From: [REDACTED]
To: [Richard Price](#)
Cc: [REDACTED]
Subject: Draft Development Consent Order
Date: 22 February 2016 14:26:05

My fundamental concerns remain about the apparent underestimation of future traffic and particularly the inability of existing feeder roads and junctions to handle even this low forecast of traffic growth. These concerns have been raised by me twice previously in writing, verbally at the Reading hearing and have also been voiced by others. Consequently, I do not intend to reiterate these concerns except to say that they do not appear to be addressed in the draft document although I expect that the Inspector's report will cover them.

Project	SMART MOTORWAYS PROGRAMME
	M4 JUNCTIONS 3-12
Drawing title	ENVIRONMENTAL MASTERPLAN
	REGULATION 4(2)(e)
	SHEET 14 OF 61
	LOWER EARLEY

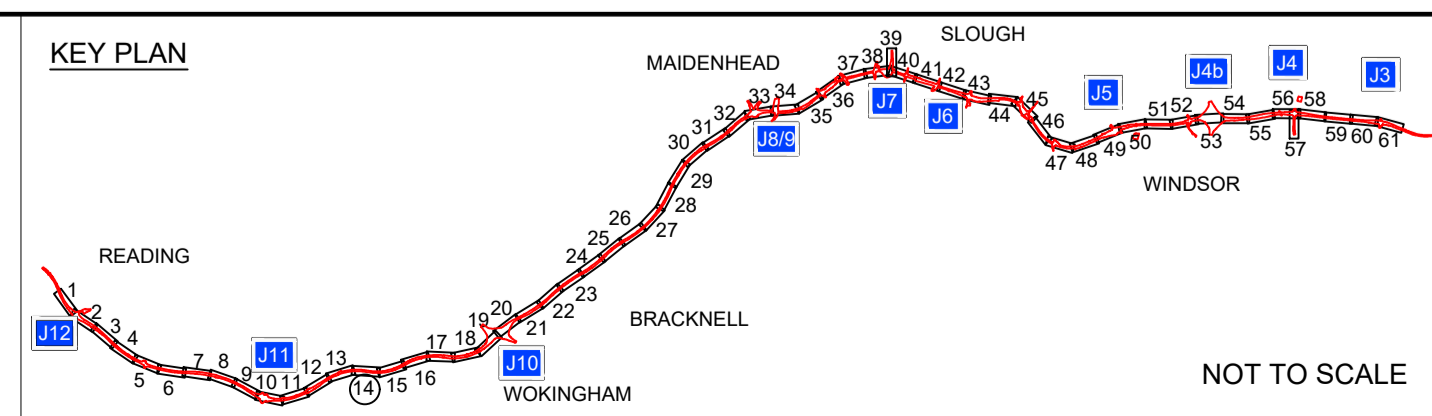
Firstly I assume that the quoted Masterplan document does not yet exist and so I must reserve my position until it is available. This said I understand that the HE stated at the most recent hearings that they were committed to the barriers covered in the Enhanced Environmental Strategy document although they had been asked by the Inspector for a further note regarding raising that proposed for Lower Earley to 3.5m.

Secondly I would prefer some tighter wording regarding when the barriers should be erected given the long duration of scheme construction. My view would be that barriers should be erected as soon as scheme construction is started for maximum impact rather than before operation which could well be 5 to 6 years later. I am sure that the Inspector will appreciate the logic of this.
